Subject: Re: FP/125/19/DOC - land adj Gun Post, Felpham

Subject: Re: FP/125/19/DOC - land adj Gun Post, Felpham

PROJECT The Beachcroft Hotel - Beach Huts DATE 29/05/19
TITLE Timber Sea Wall DRG NO IBA/510/SK10
SCALE NTS REVISIONS

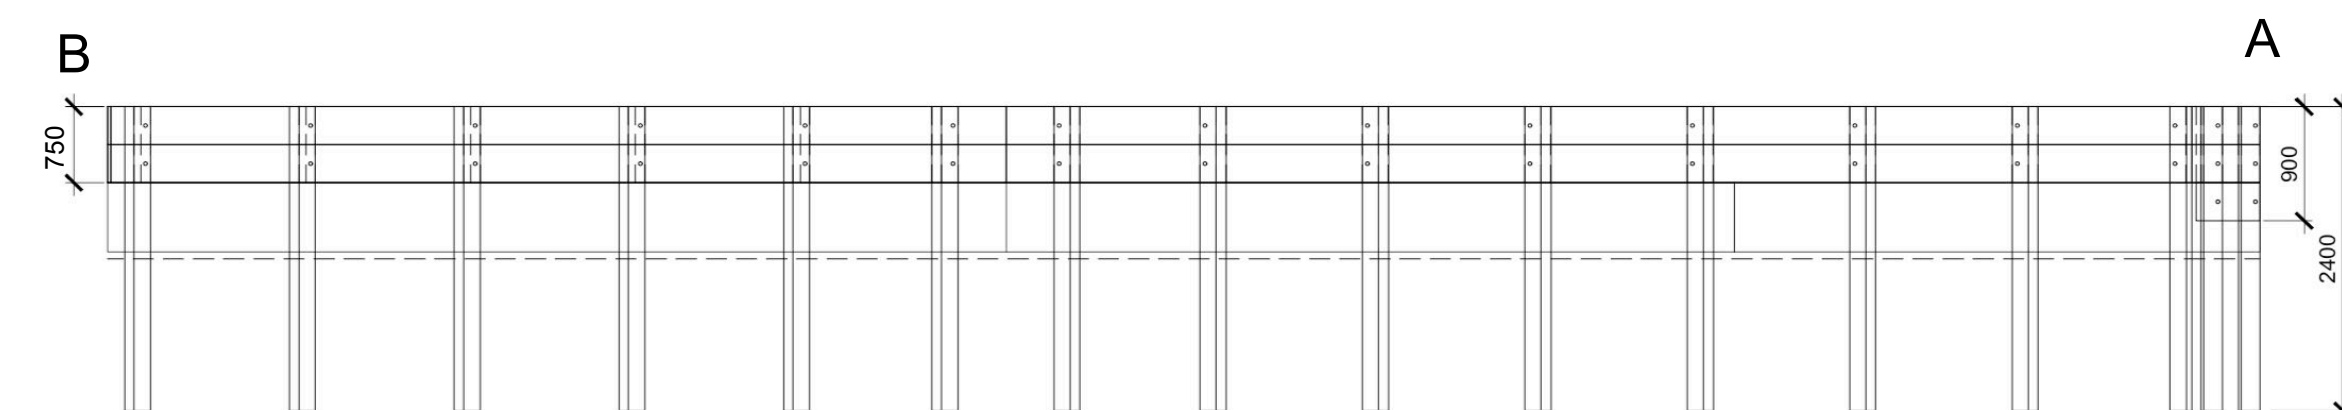
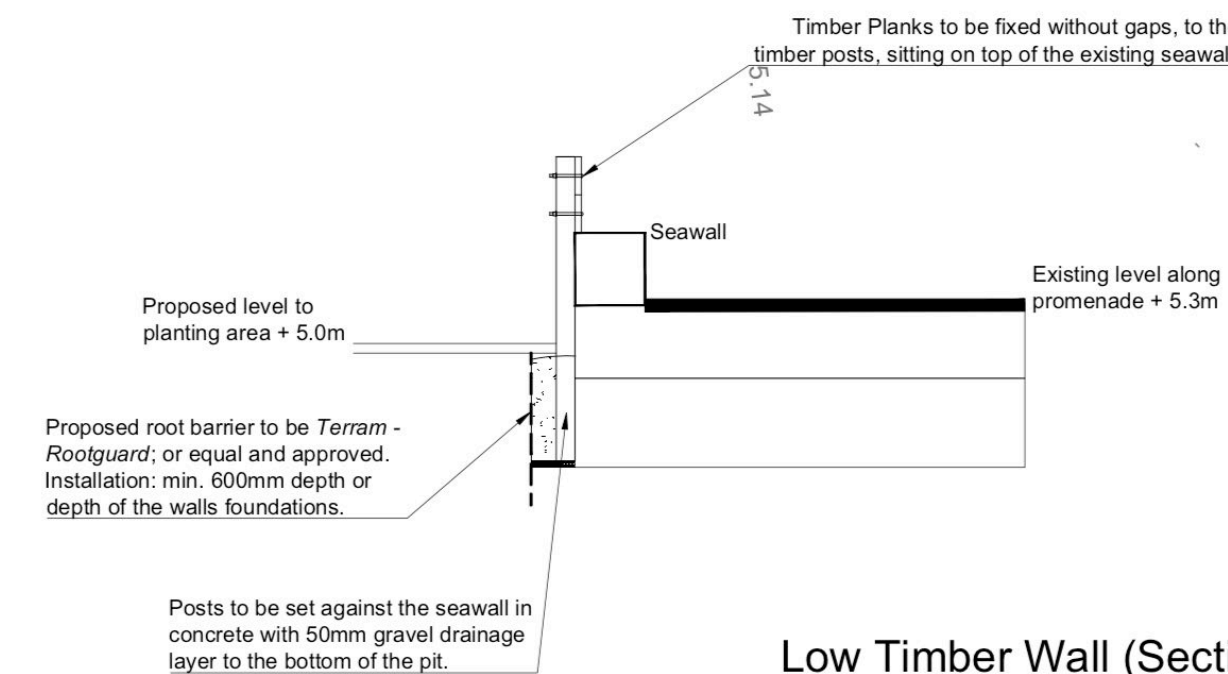
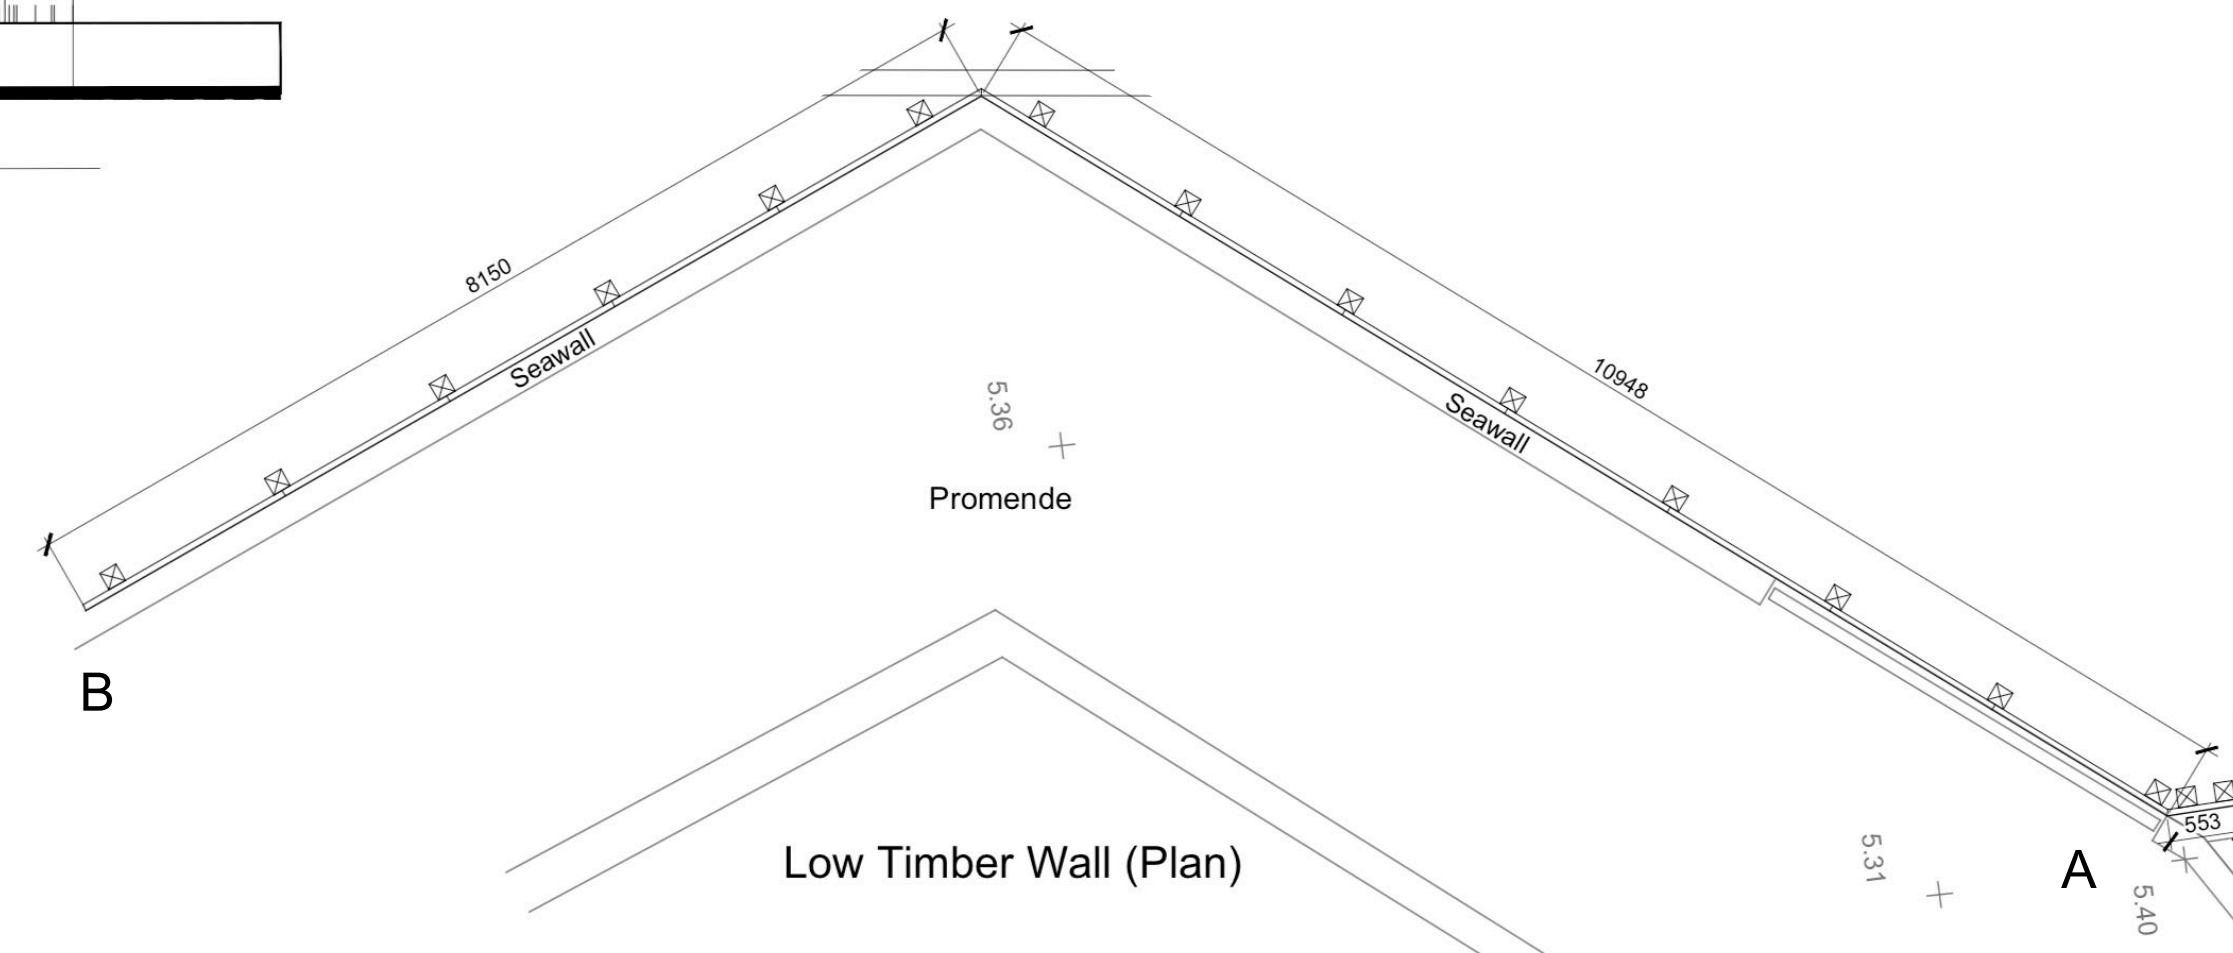
Following our conversation of last week please find response from our Engineer.
Can you confirm height? If it is as described below please provide correct plans.

“Following an inspection of the site last week I can confirm that the applicant has, in principle, constructed the asset in accordance with the approved plans. However, I am led to believe that the timber planking has been placed higher than the stated “600mm above the seawall”. Unfortunately, I didn’t have a tape measure to hand but I estimate the timber wall to be approximately 150mm higher than that stated in the approved drawing. From a Coast Protection standpoint this is not something that will adversely effect the structure and I can therefore confirm it is to the satisfaction of our department.

Provided the additional height is not a problem for the planning department I can therefore recommended that this condition be discharged.”

Hi Daniel. The height is 750 mm rather than 600 from the top of the sea wall. I think it is noted on the drawing. Regards. Ivon
